June 30, 2017

Ms. Helen Donaldson
City of Portland Planning Authority
4th Floor, City Hall
389 Congress Street
Portland, ME 04101

**RE: AC Hotel Portland
Plan Set Revision Summary**

Plan Set Sheet Revision / Update Summary

No.	Revision/Issue	Date
Design by:	MPM	Checked by: SJB
Drawn by:	JAR	Approved by: SJB
Project:	150.06094	Date: AUGUST 2015
Sheet No:	C1.1	
	Sheet 5 of 17

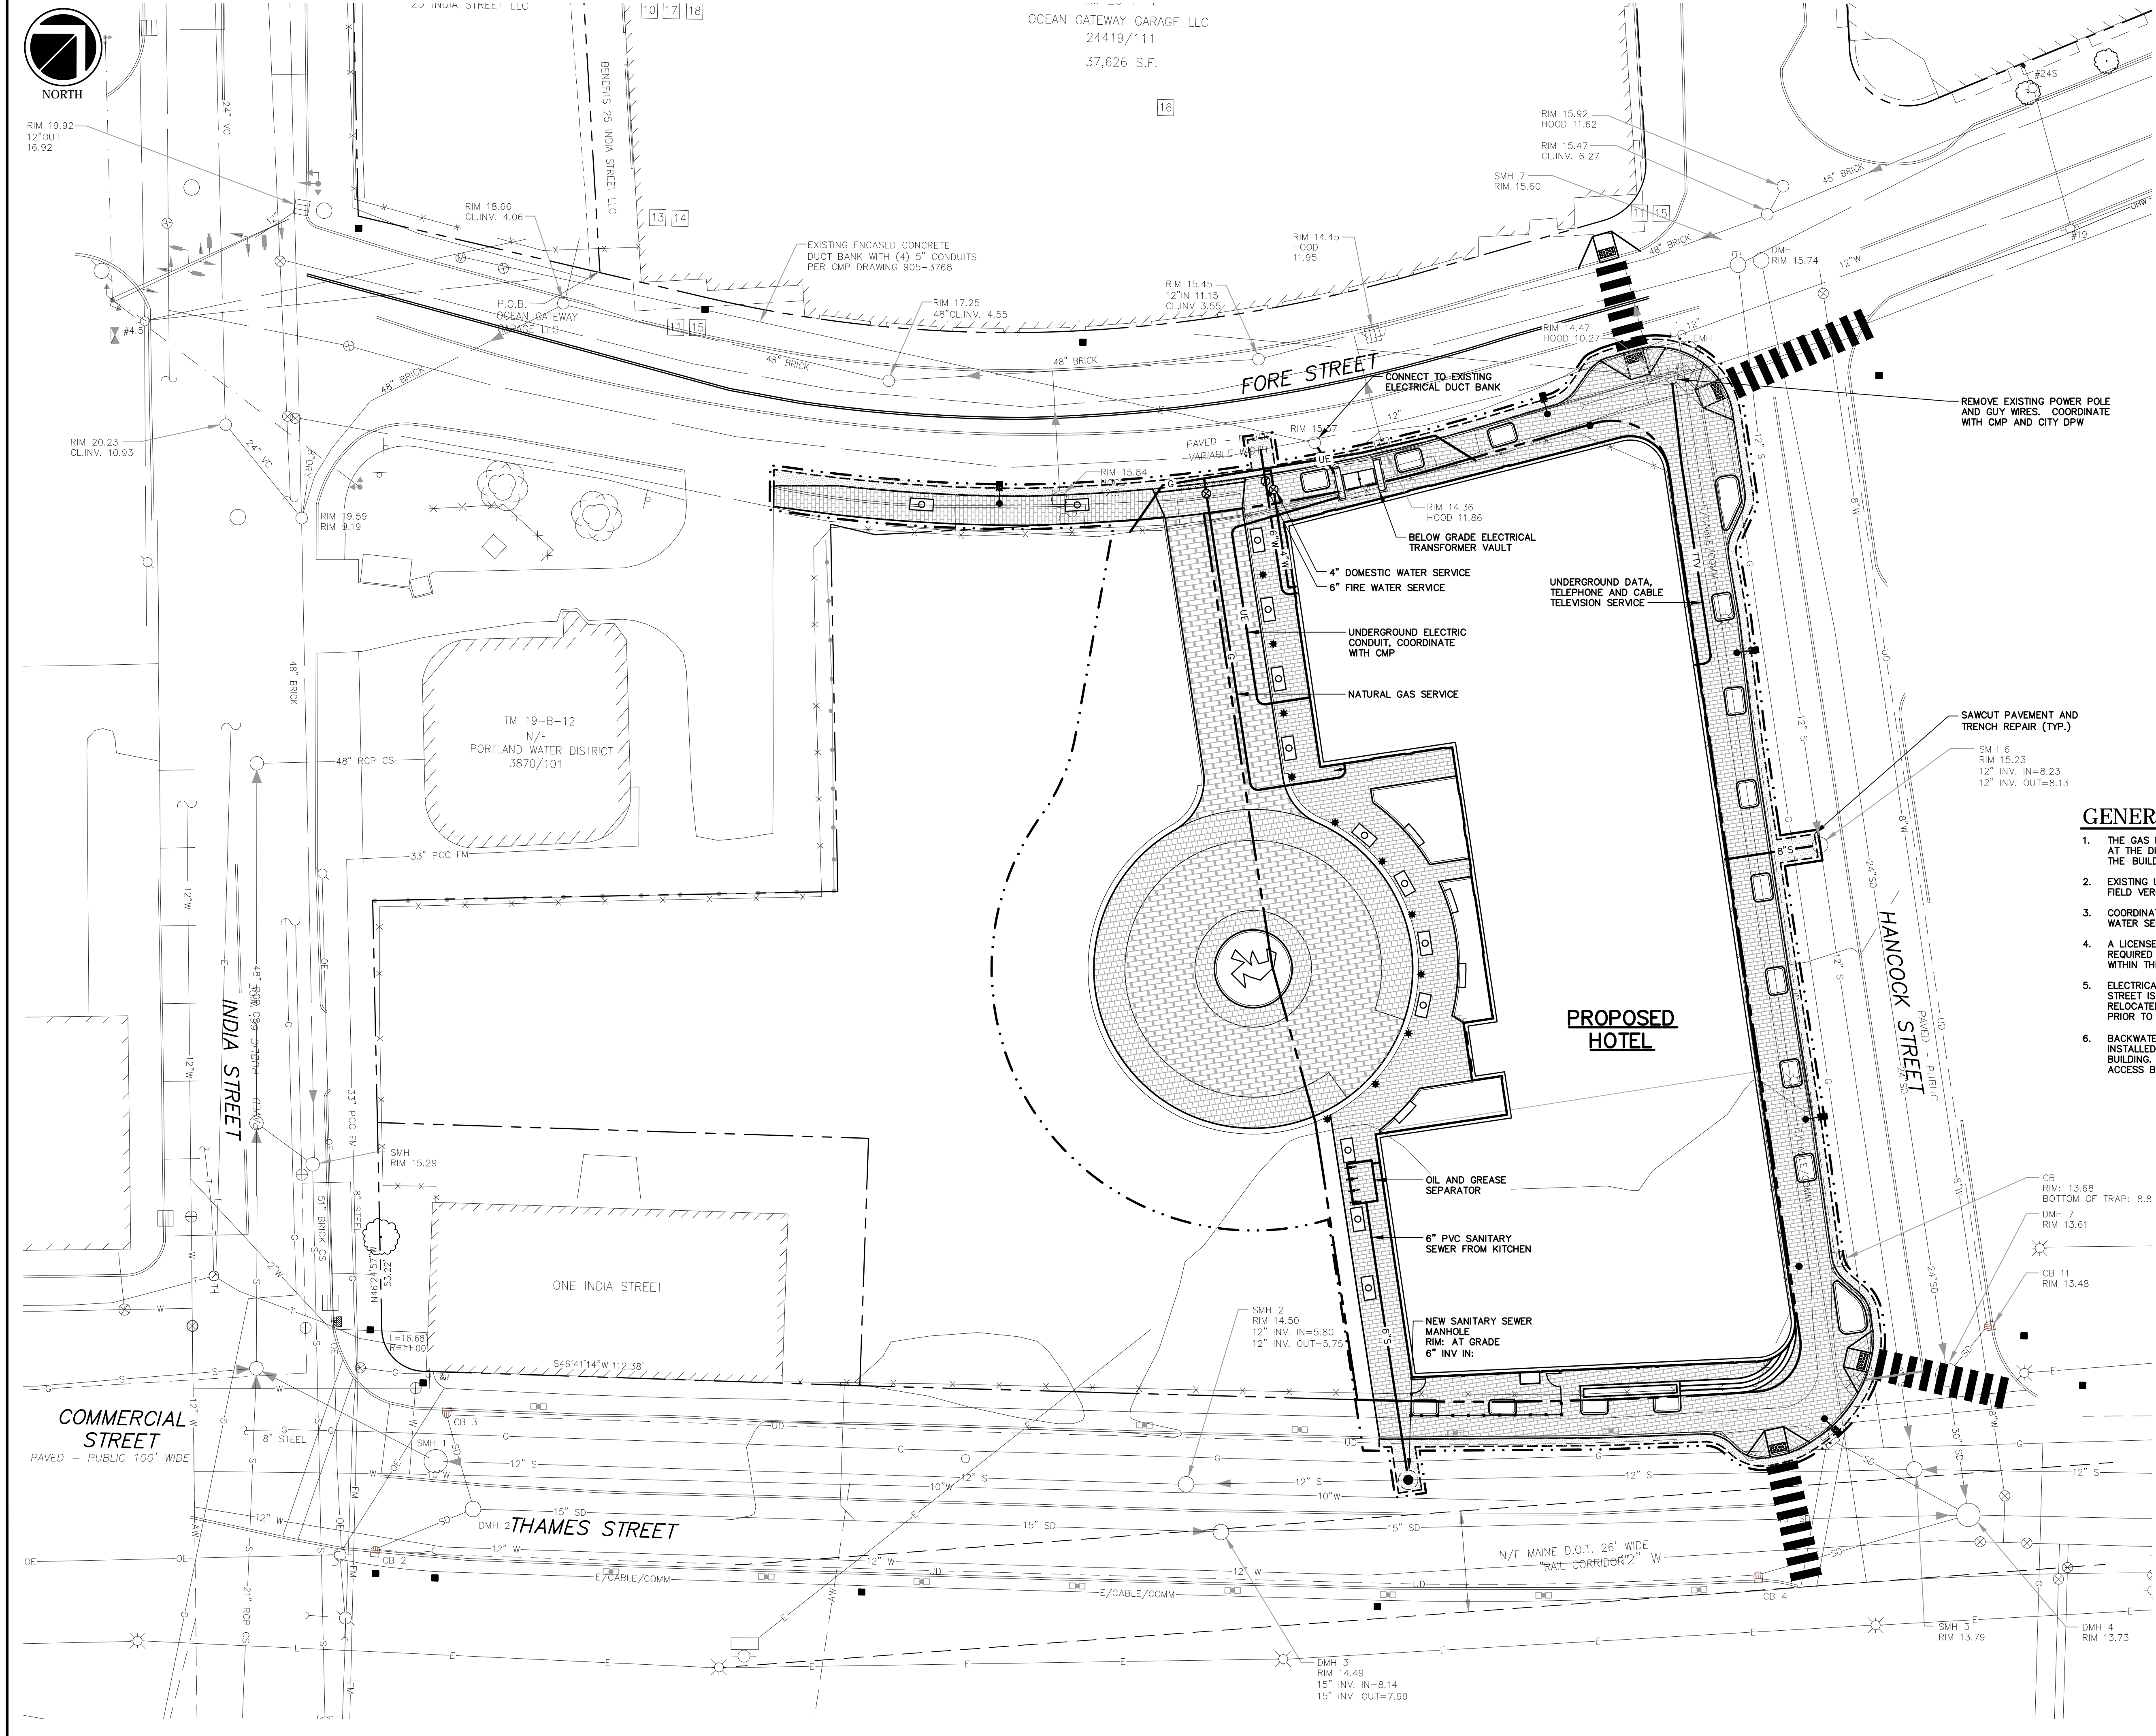
Revisions: Revised location of gas main. Detail of water connection.

No.	Revision/Issue	Date
Design by:	MPM	Checked by: SJB
Drawn by:	JAR	Approved by: SJB
Project:	150.06094	Date: AUGUST 2015
Sheet No:	C1.2	
	Sheet 6 of 17

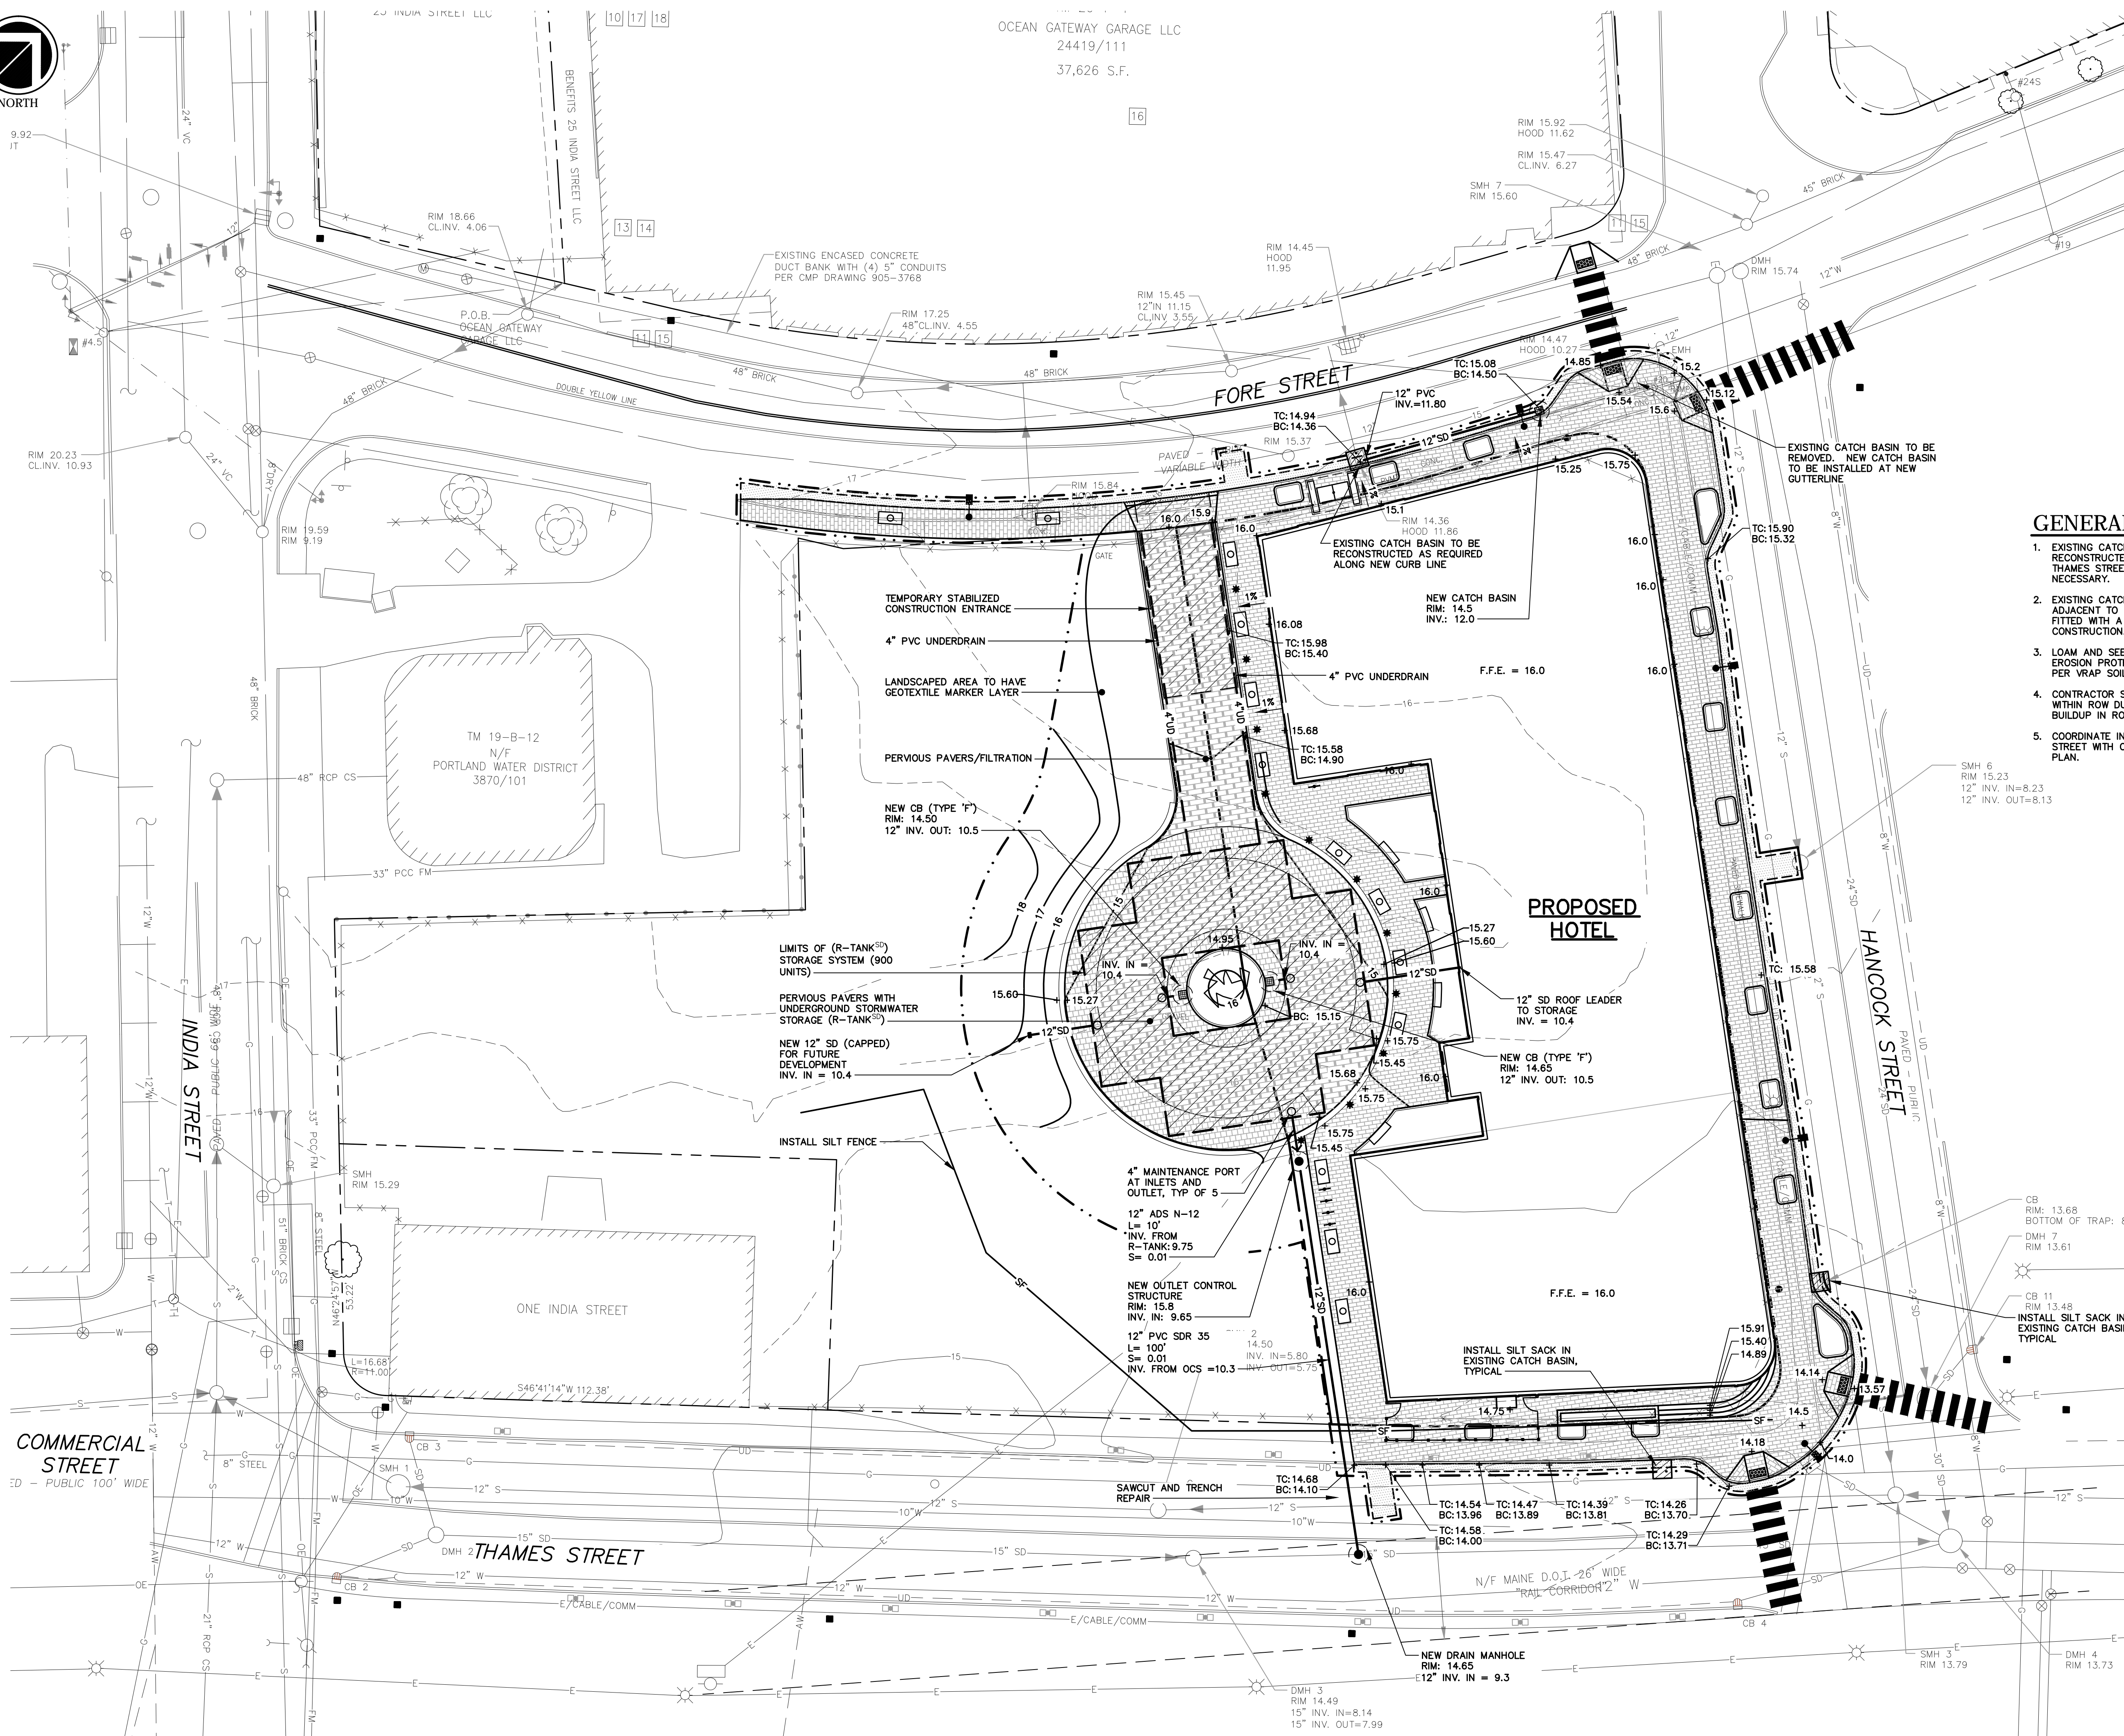
Revisions: Site revisions (see C1.0), install new precast catch basins at curb rather than reusing/adjusting existing brick catch basins, revised location of 12" SD, revised or additional spot grades.

Sheet No:
L1.0
Sheet 1 of 00

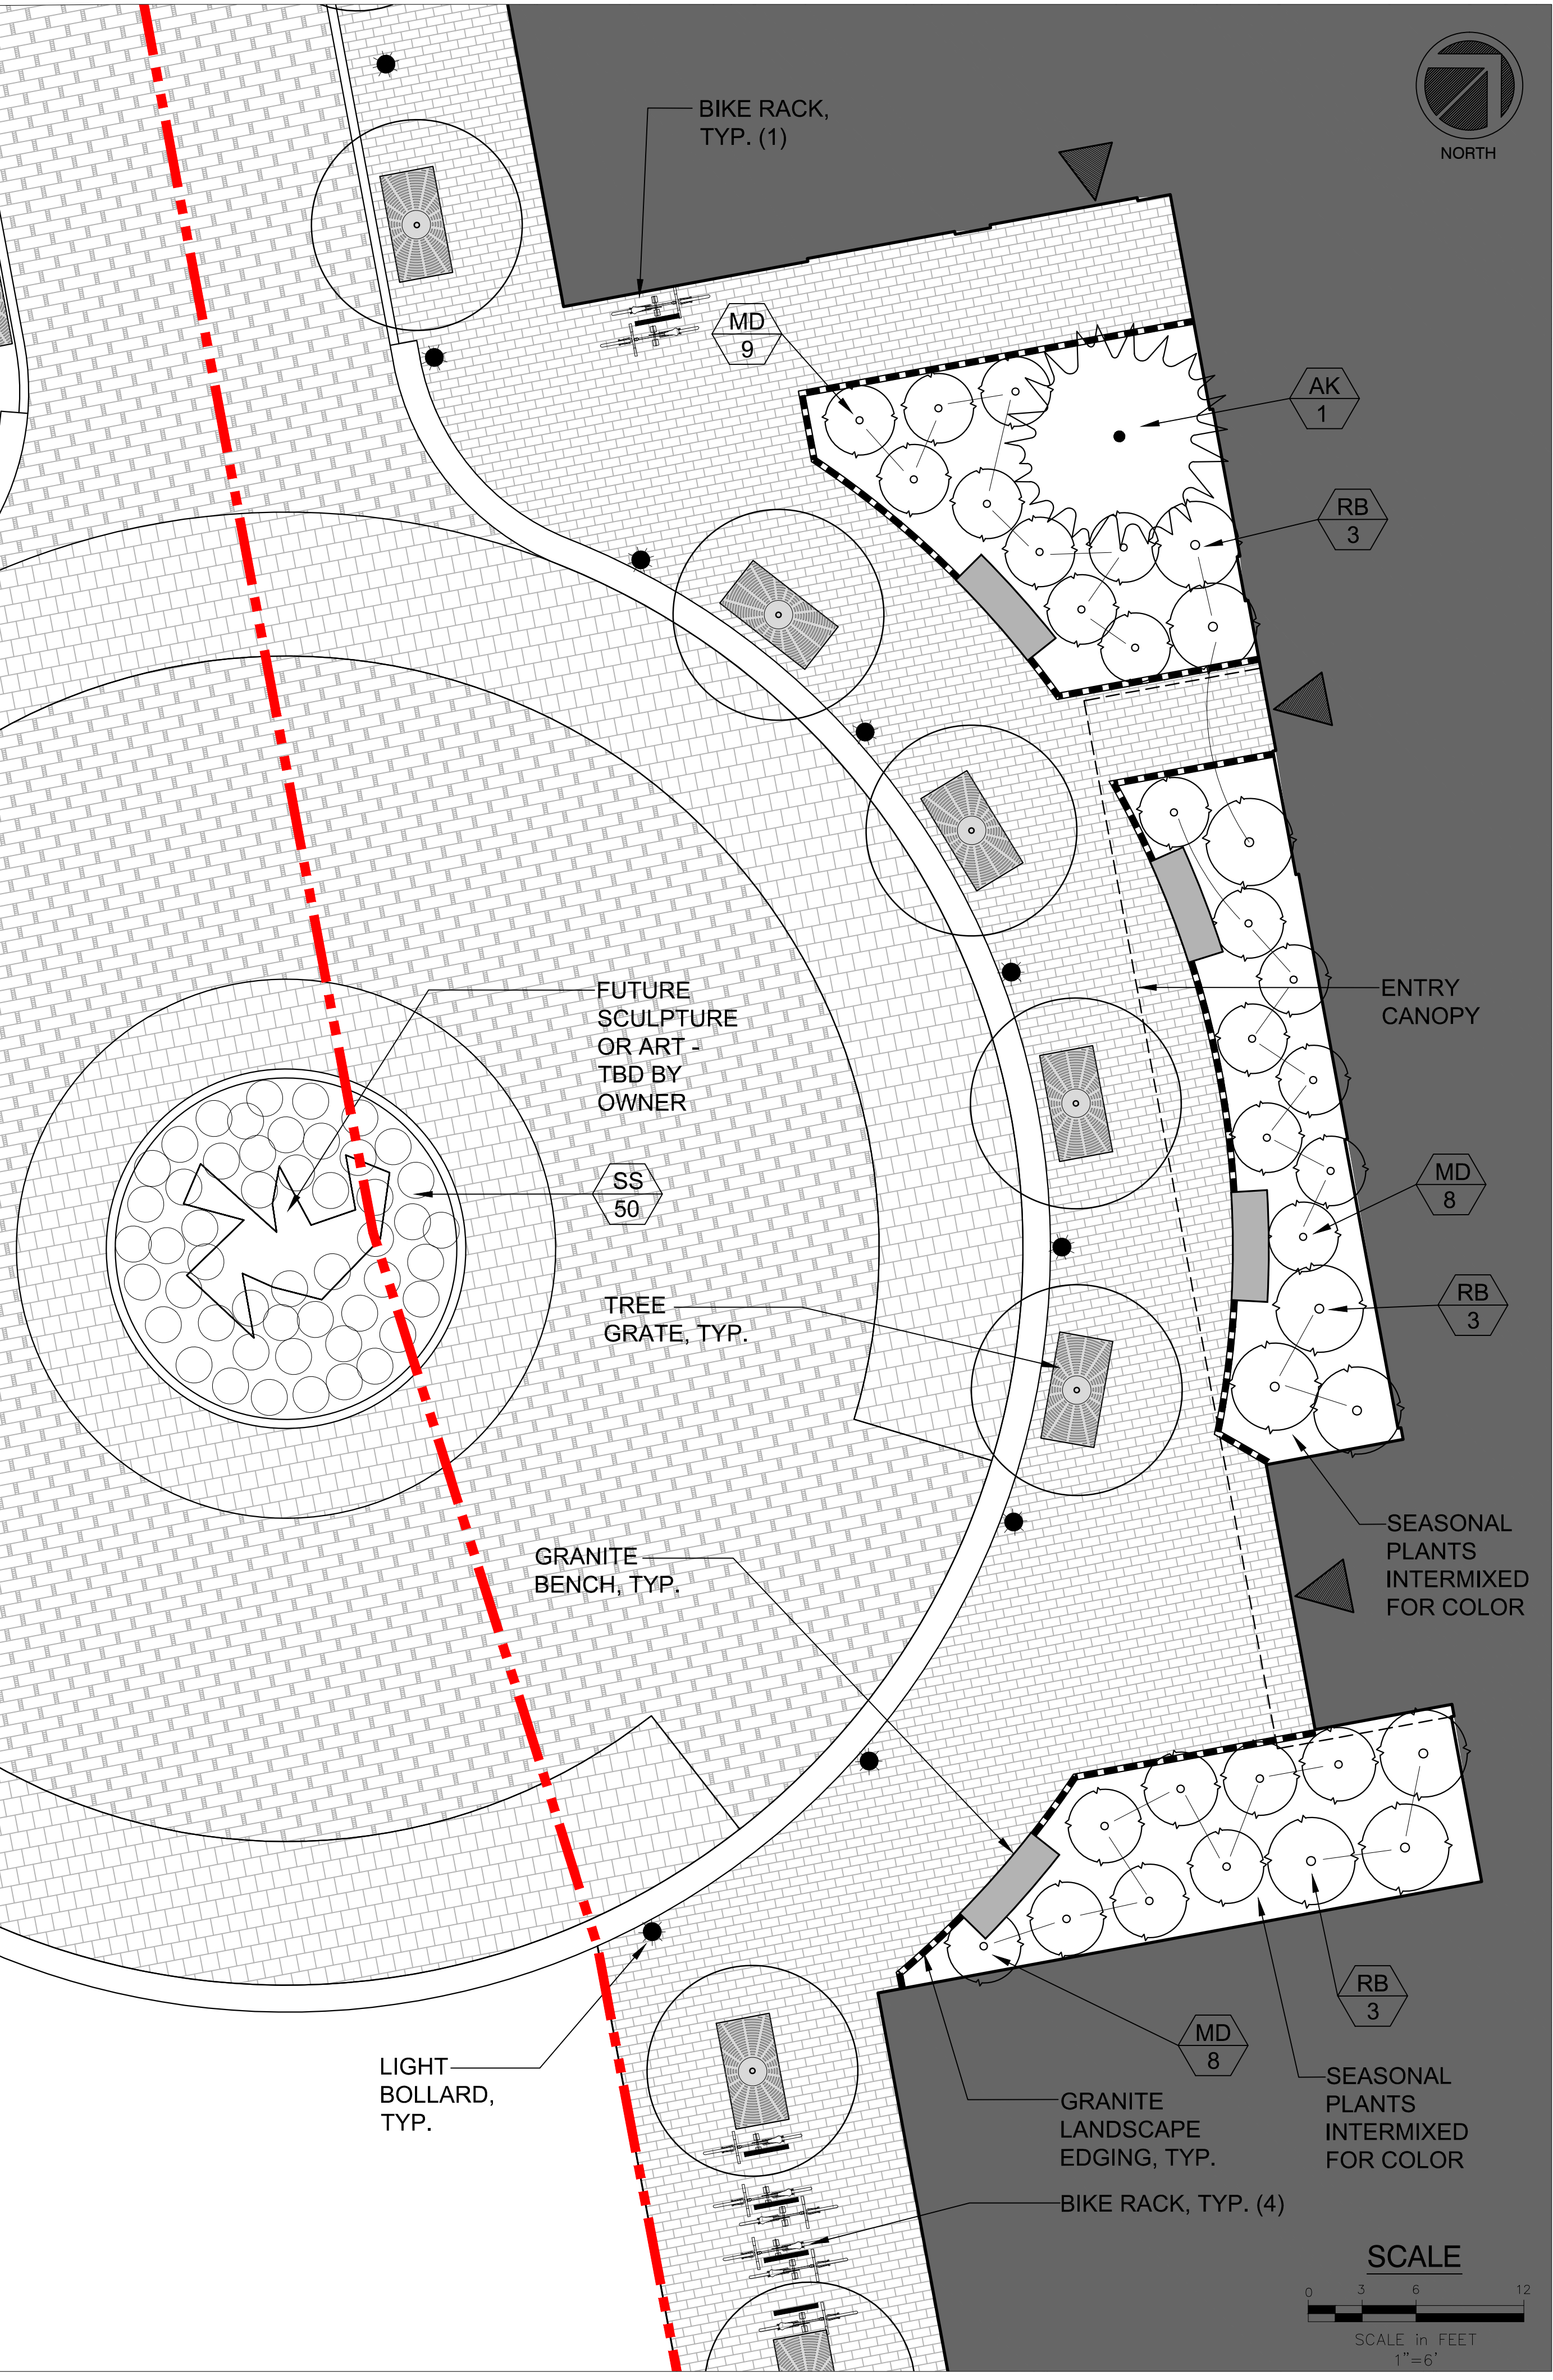
Revisions: Relocate all bike racks (5) to one central location adjacent to the drop-off circle, reduce size of adjacent landscape bed, increase # of plants in three landscape beds adjacent to hotel entry and central turning circle, relocate street light from intersection of Thames/Hancock Streets to in-line with others proposed along Thames Street, adjust curved step radius and termination point along Thames Street, reconfigure street trees and seatwall (adjacent to steps) along Thames Street, and remove streetscape improvements along Fore Street, south of entry driveway, from hotel project (3 street trees, 1 street light, and brick sidewalk - to be installed with development of Lot #2).
